Developer Services
Southern Water
Sparrowgrove House
Sparrowgrove
Otterbourne
Hampshire
SO21 2SW

Your Ref
F/19/18/EIS
Our Ref
PLAN-025784
Date
05/12/2018

Proposal: Scoping opinion for development of up to 1,500 dwellings, up to 37,000 sqm of employment floor space, a local centre including retail, commercial and community facilities, primary school, nursery, a care/retirement home, healthcare facilities, public open space, new sports pitches and facilities, & associated access, infrastructure, landscape & ancillary works
Site: Ford Airfield, Ford, BN18 0HY.
F/19/18/EIS

Southern Water MapGuide Browser

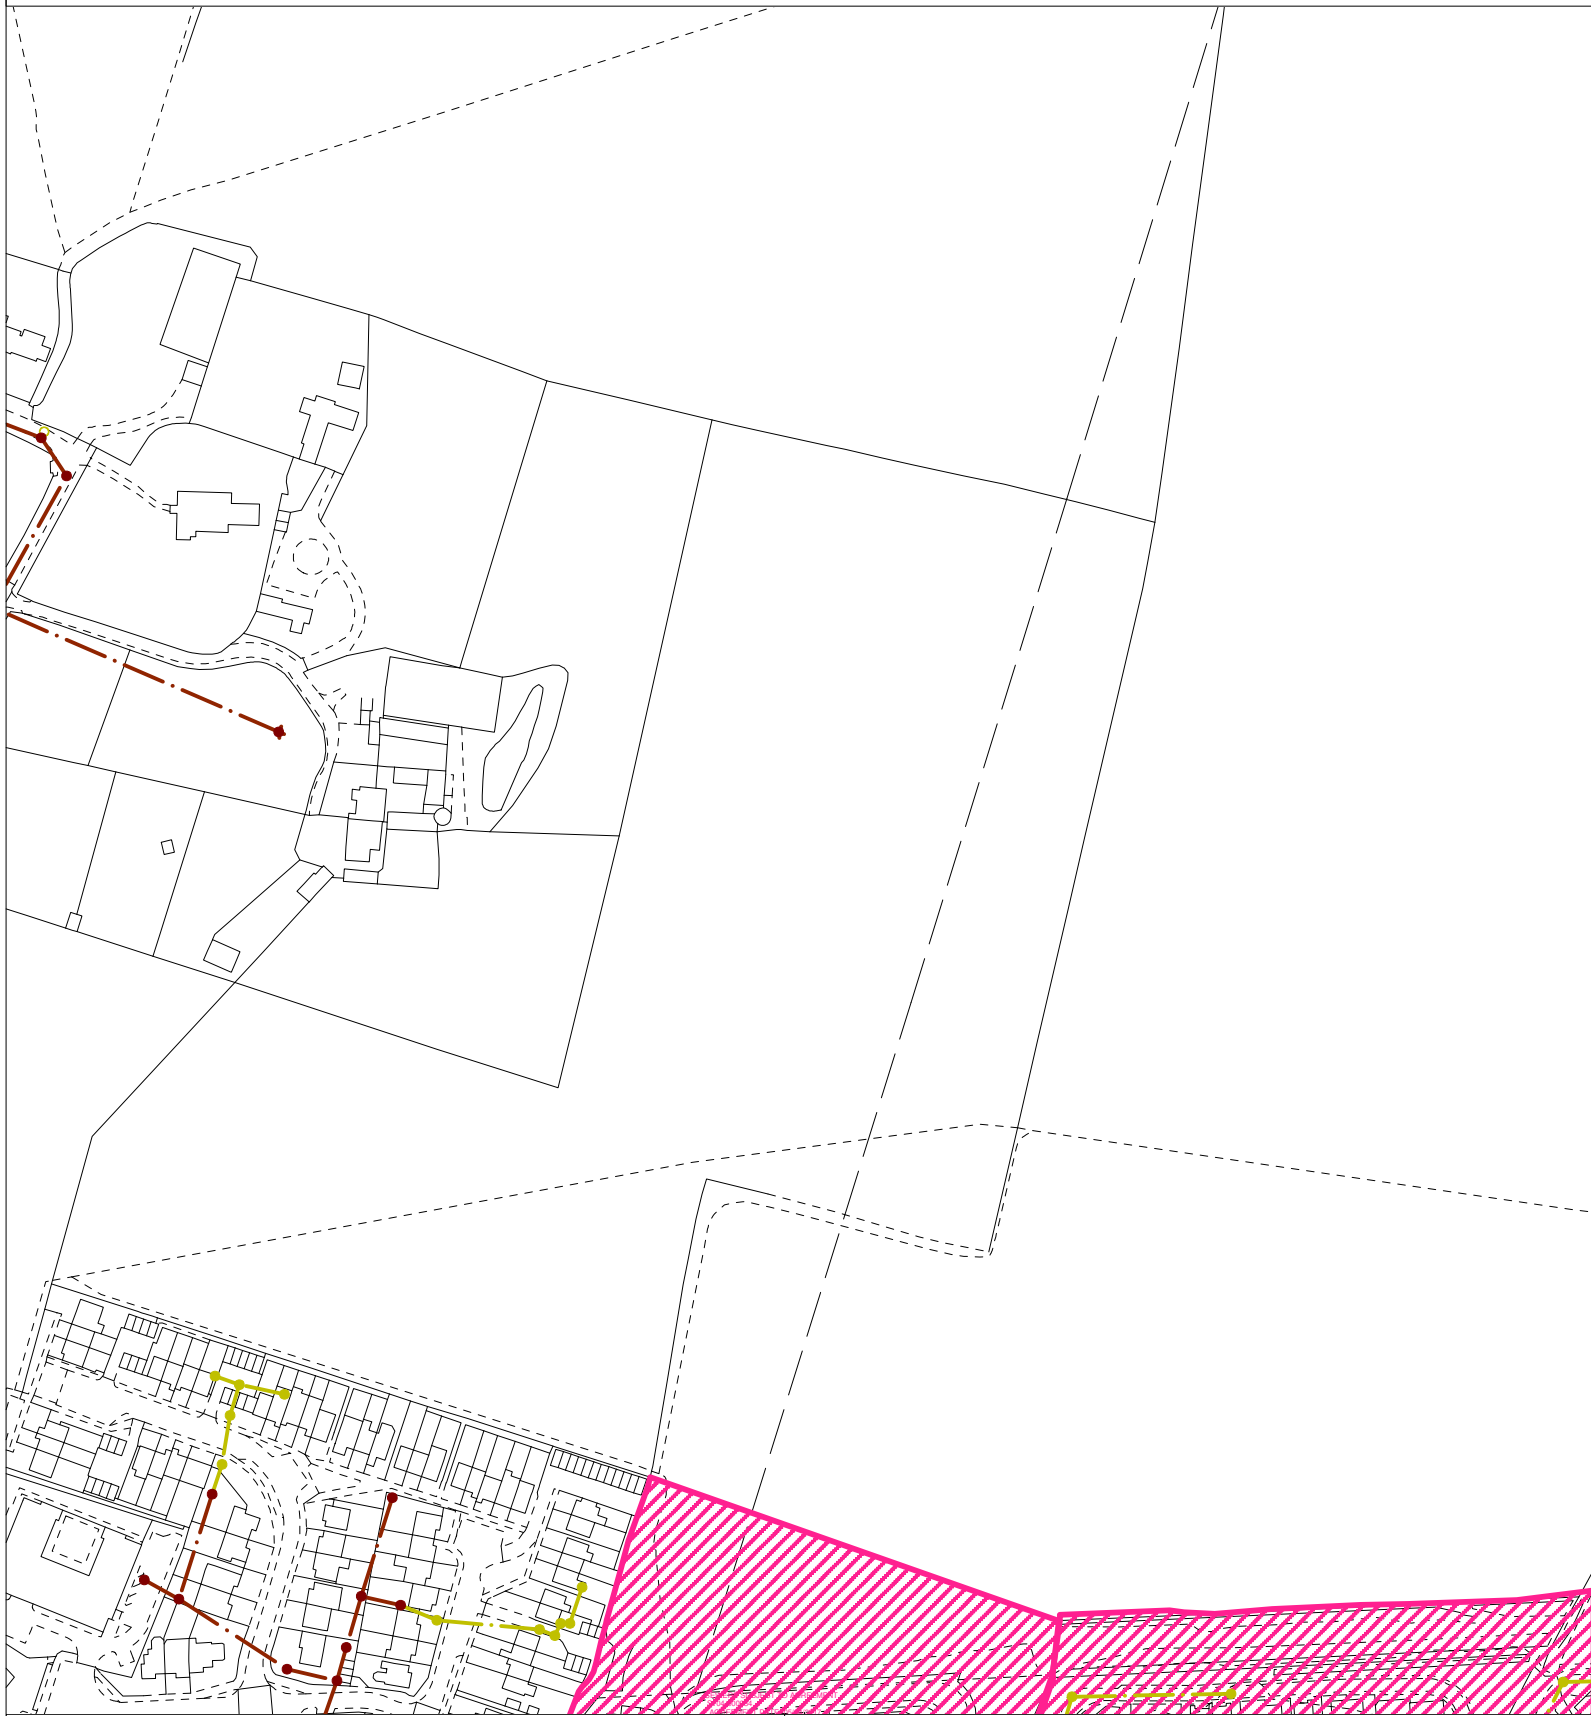
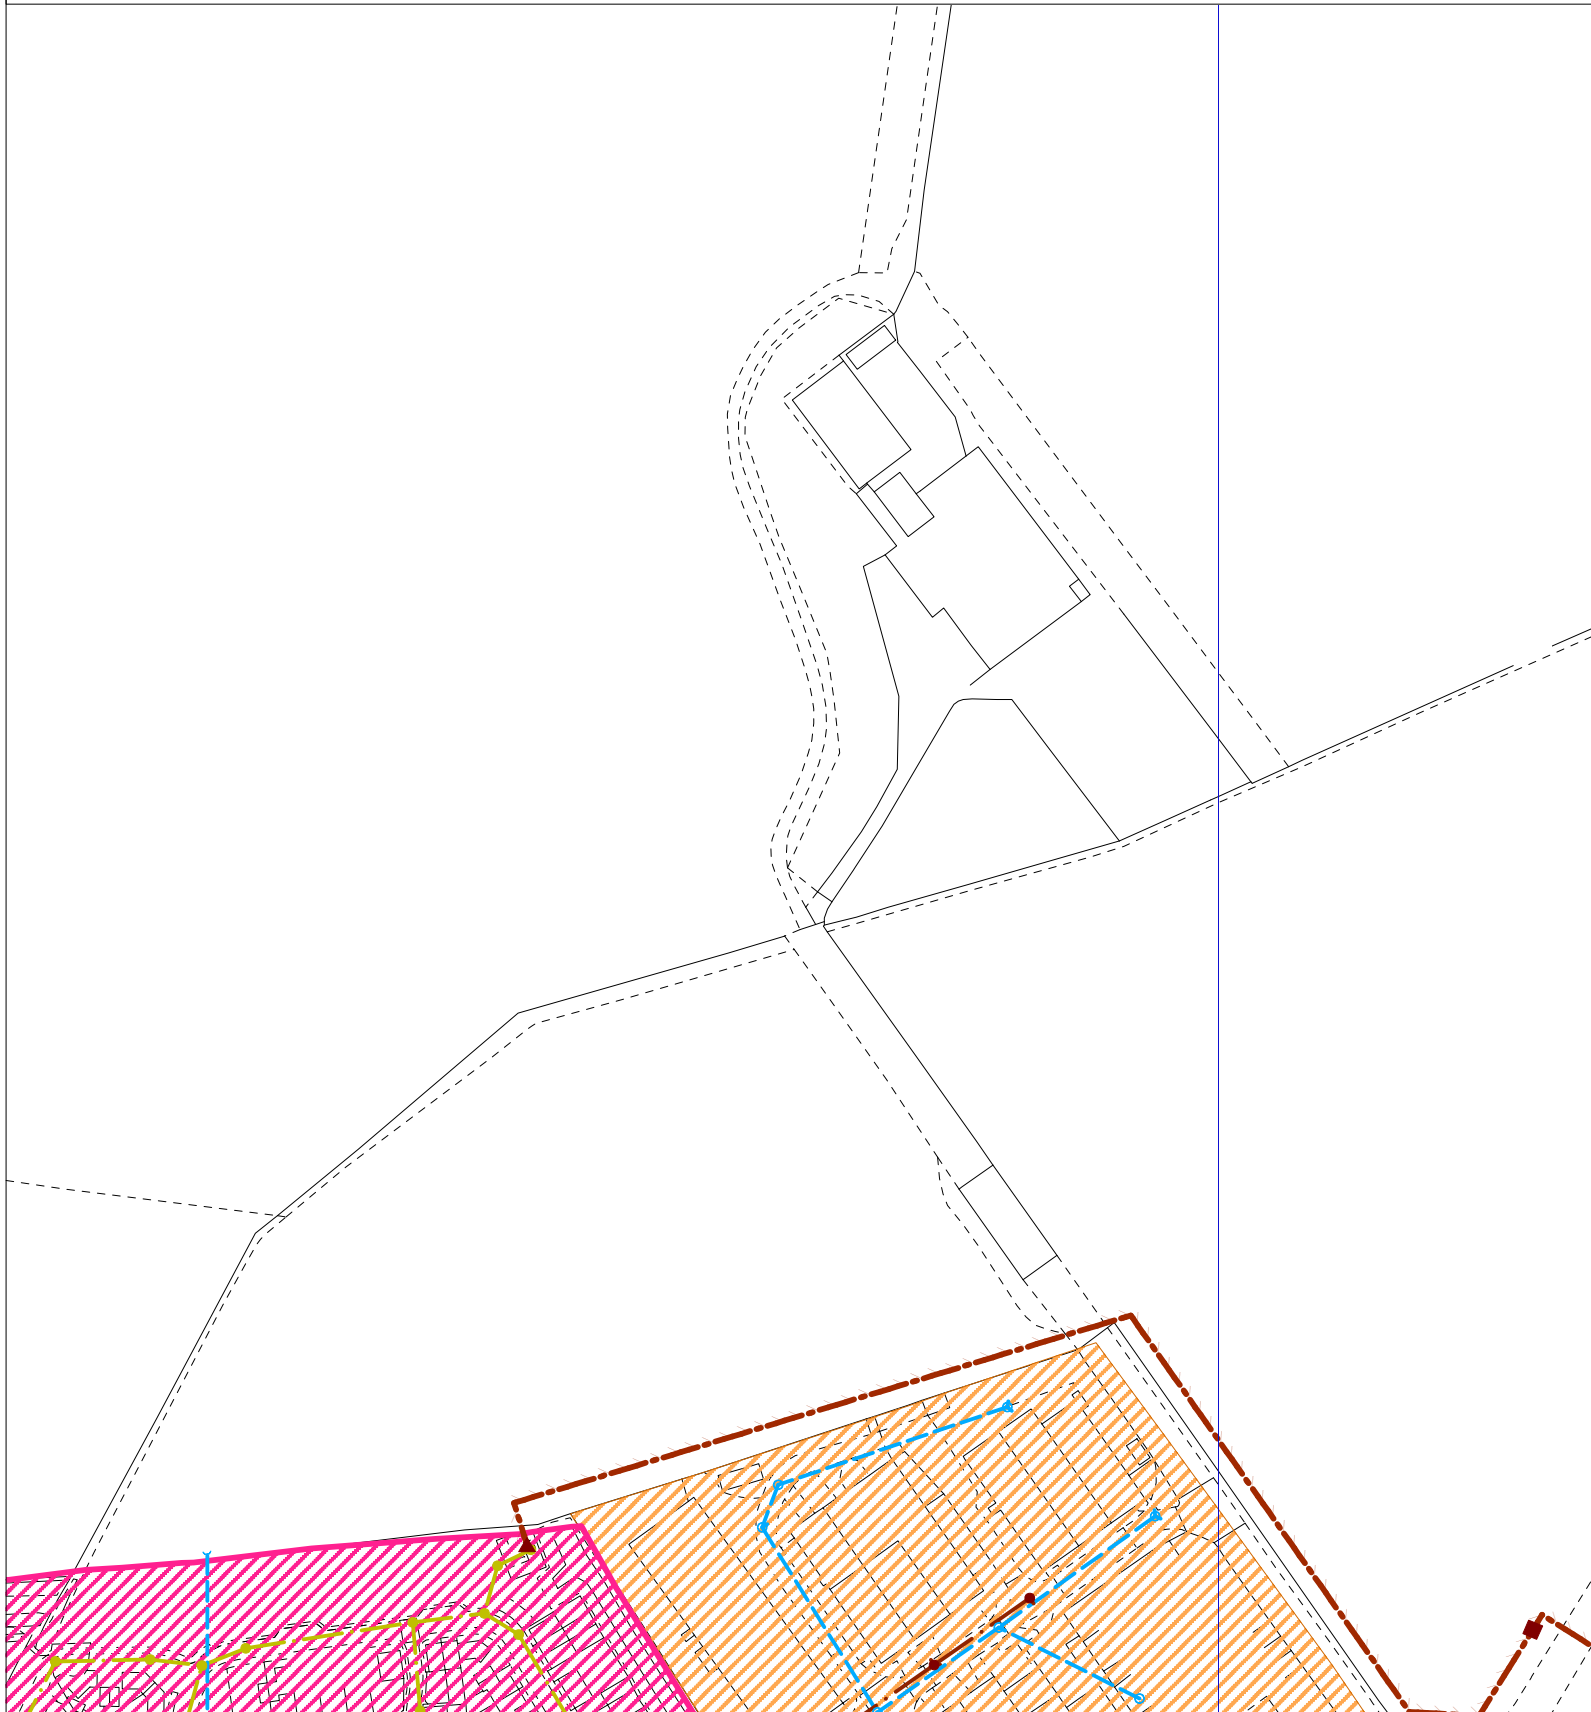
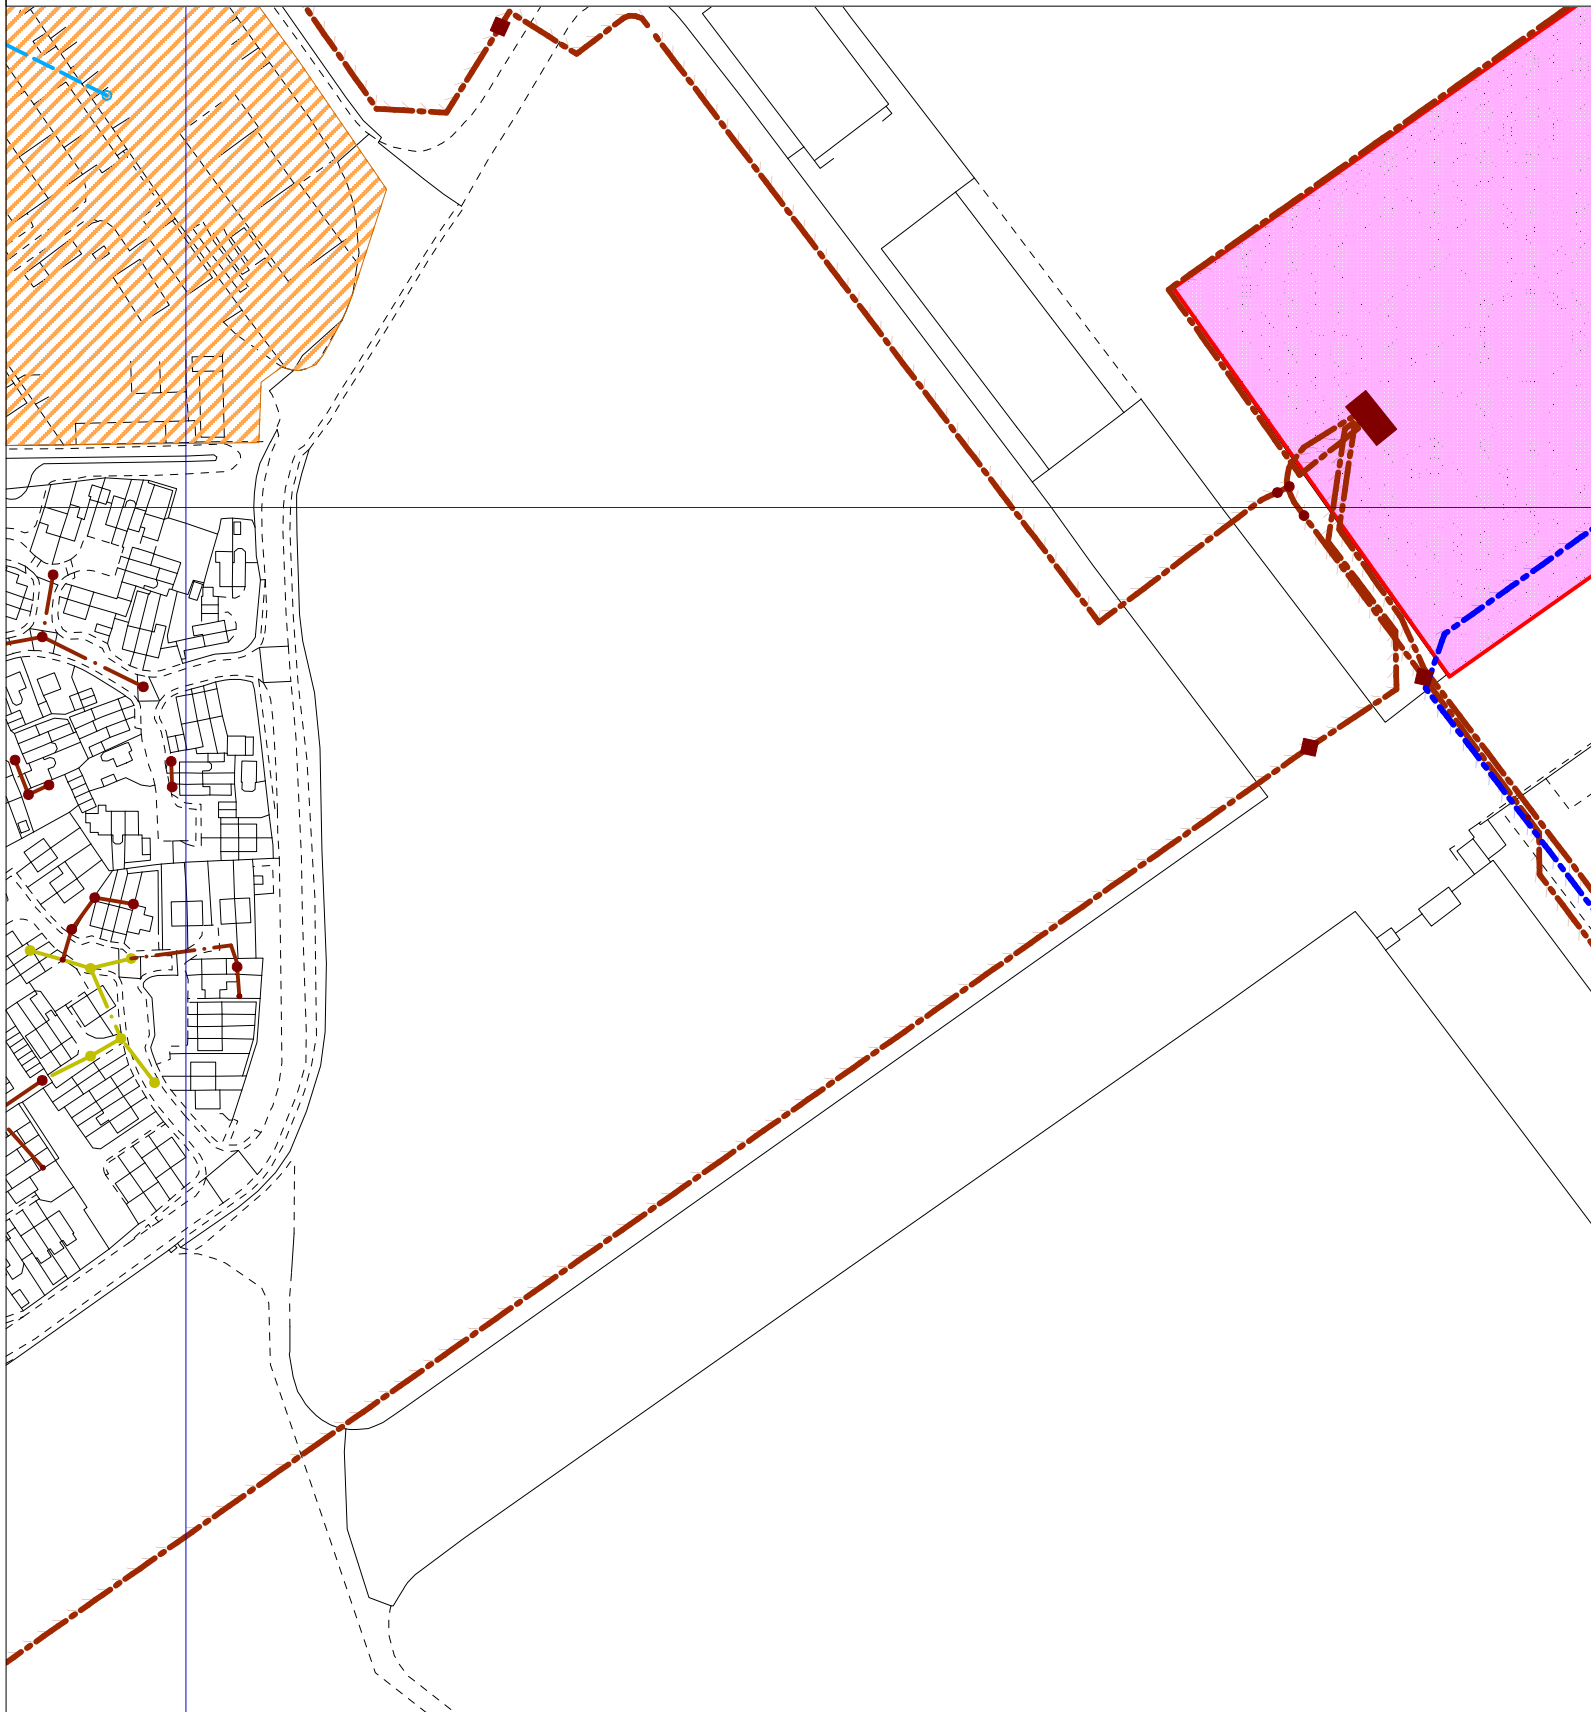
- Southern Water's current sewerage/water records show that there are foul rising mains (100mm, 125mm, 180mm, 500mm & 600mm) and 700mm (treated effluent) rising main within the proposed development site.
 - No new development/building works will be permitted to be constructed over or within 3.0 metres of the existing 100mm, 125mm, 180mm foul rising mains. Sewer record attached for your information.
 - No new development/building works will be permitted to be constructed over or within 3.5 metres of the existing 500mm and 600mm foul rising mains. Sewer record attached for your information.
 - No new development/building works will be permitted to be constructed over or 4.0 metres of the existing 700mm (treated effluent) rising main. Sewer record attached for your information.

- No new soakaways should be located within 5 metres of a public sewers and rising mains.
- In addition, due to changes in legislation that came in to force on 1st October 2011 regarding the future ownership of sewers it is possible that a sewer/s now deemed to be public could be crossing the above property.
